Further to our previous email responding to the conservation officers comments on Thatch Cottage - I attach a drawing 02 305 which gives a detail of T&G board detail used on external wall cladding of new extension and includes the sliding door detail for windows 3, 4 & 5 in the new extension. Drawing 00 311 provides a detail of shutters to windows in flint walls, and whilst the elevation is of a window in Mill Cottage, the details are the same for all windows in flint wallsThatch i.e.. windows 6,7,8 ,9 &10.

We have read through Martyn White's (Conservation officer) comments on Thatch Cottage applications CM/42/19/PL and CM/43/19/L which are very useful and encouraging and we would like to confirm and respond as follows:

Thatch Cottage:

WG.03n & WG.04n
Hardwood Sliding Door
FINISH: Black stained HW
GLAZING: 24mm DGUs, Argon filled
IRONMONGERY: Bronze external hinges or sliding stays, handle, Mortice latchlock, Mortice deadlock with thumbturn

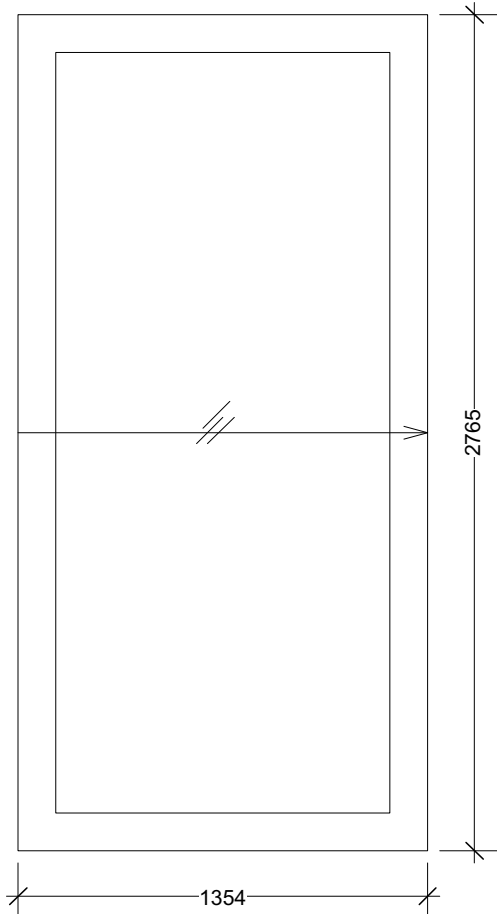
- T&G board detail used on external wall cladding of new extension
- Shutter details: Window 9 - proposed storm window - we stated "looks better if openings flush with window frame" — MW states "this is matter of detail" . We will provide a detail.
- Windows 3 & 4 - we understand MW not clear how the shutters operate - they slide in front of external wall. We will provide detail.
- Detail of stone paving specification on external terrace.
- Simple landscape of external garden if required, see note above.
